Re Planning Application R/42/15/HH

I have the following comments regarding the above application, which relates to a property neighbouring my own:

1st FLOOR PLAN 1:100@ A3

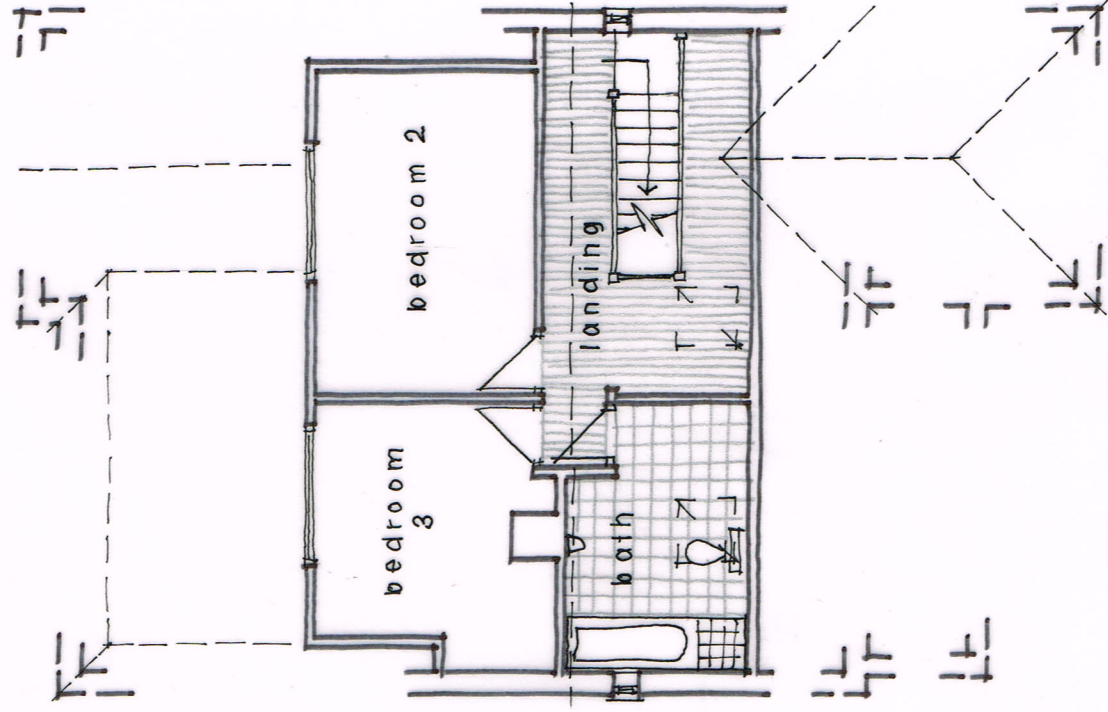
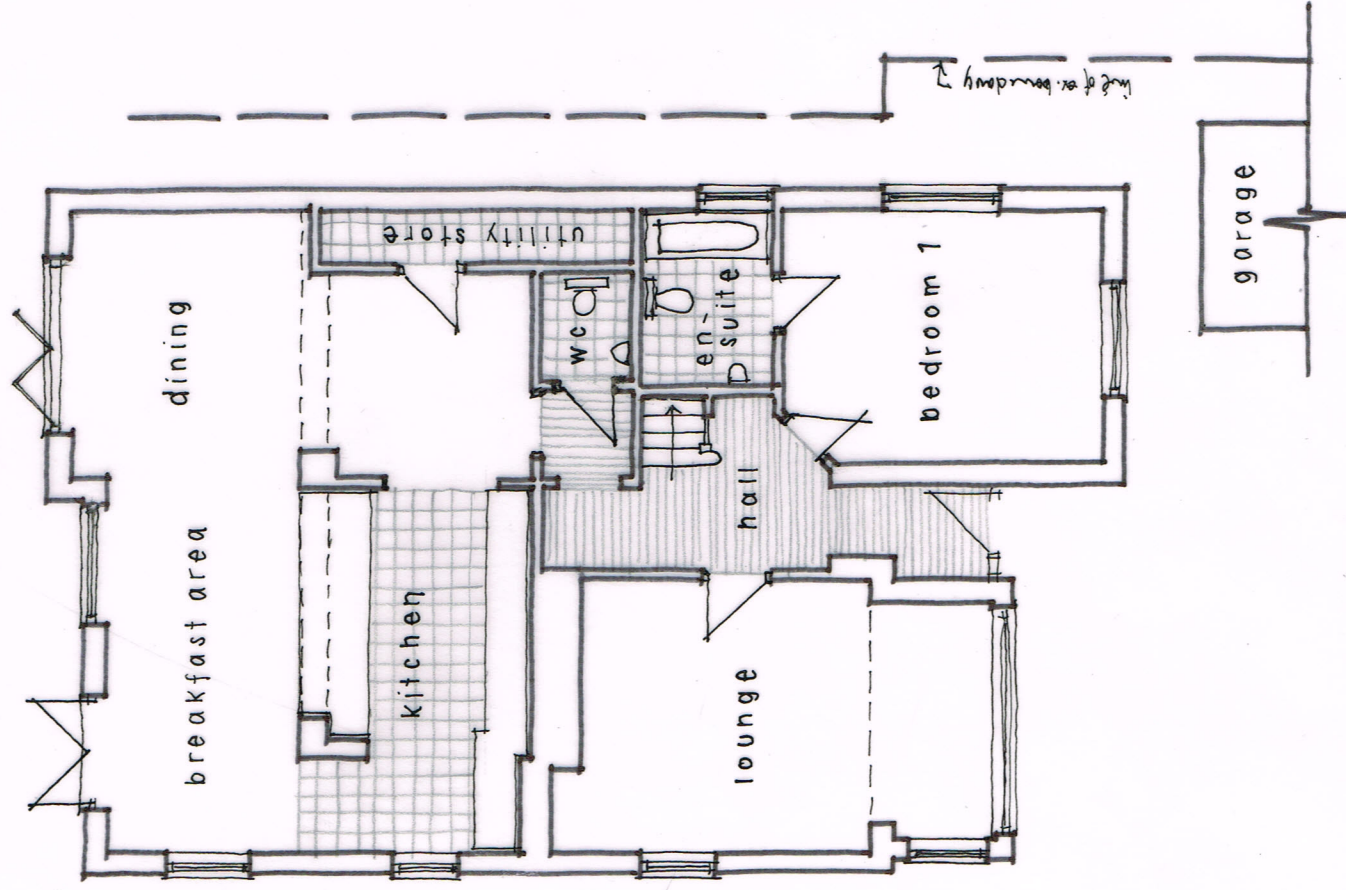
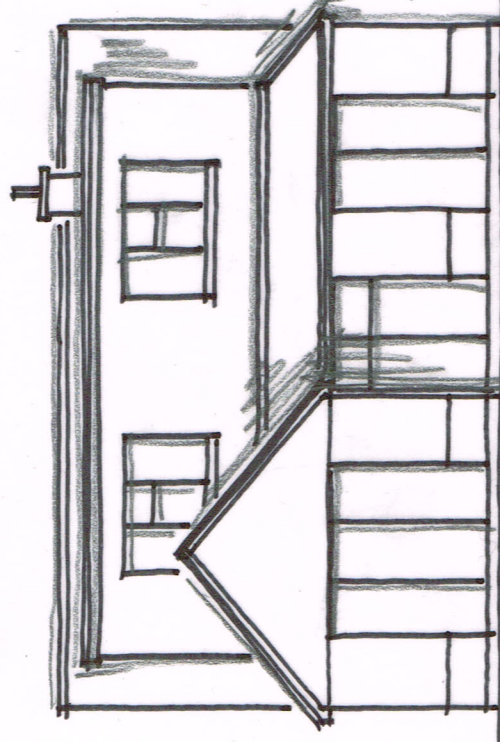
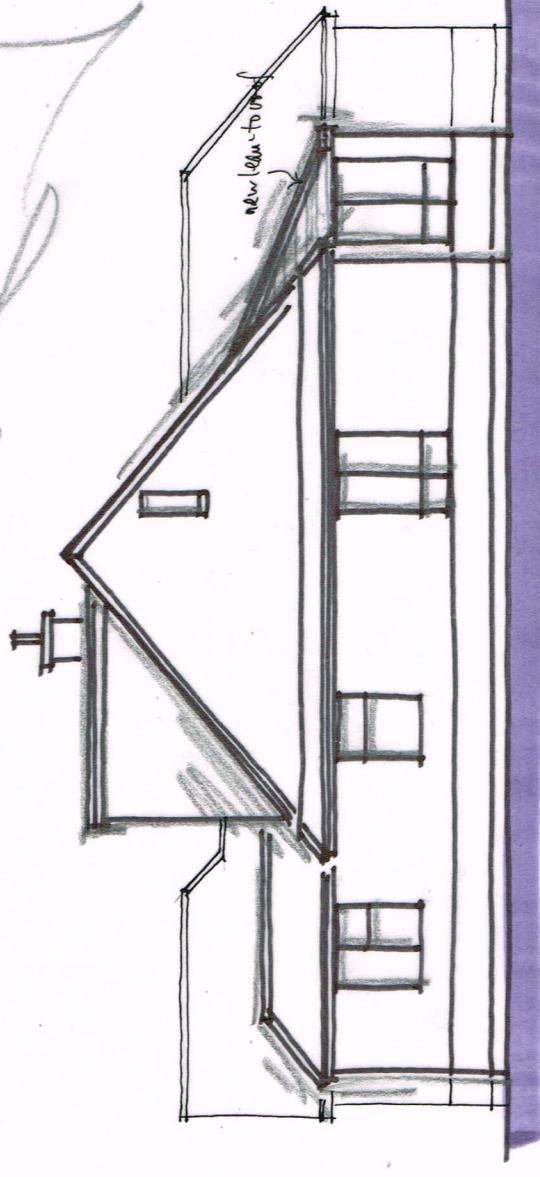
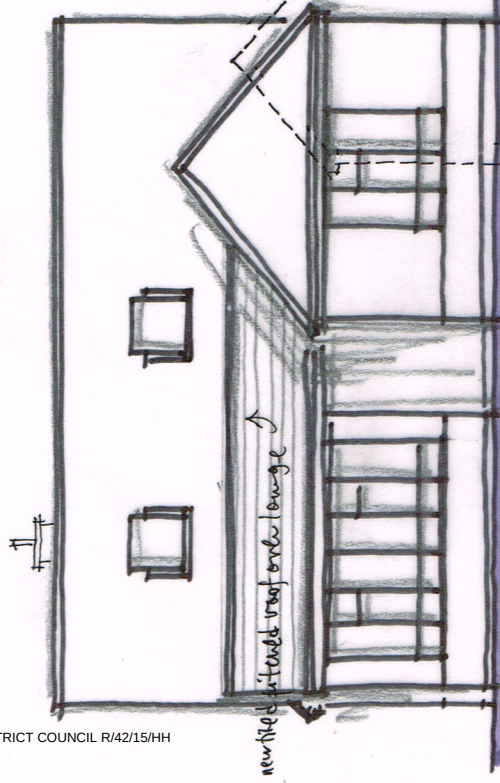
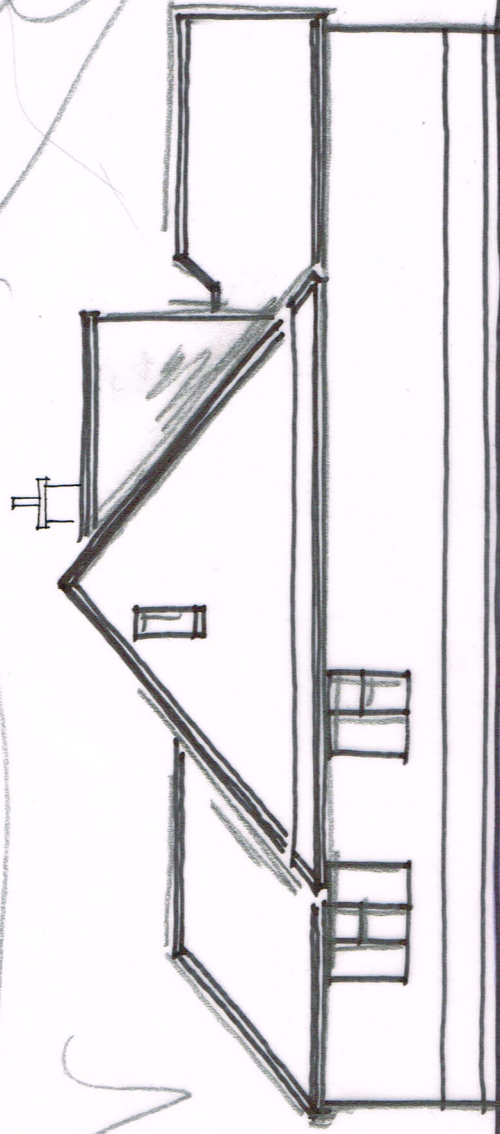
Firstly, it is proposed that the work covered by this application be carried out in conjunction with the works approved in an earlier application, namely R/153/14/HH, which include a first floor extension over an existing ground floor bedroom, and a new front dormer window. However, the "Proposals" plans for the later application, labelled "Proposals 10" do not show the first floor extension, nor the dormer window, and do not appear to be compatible with them.

Secondly, the earlier application describes the dormer window as being "to serve existing first floor bedroom", whereas the plans, labelled "Proposals 02" seem to indicate that the dormer is to serve an existing bathroom, not bedroom.
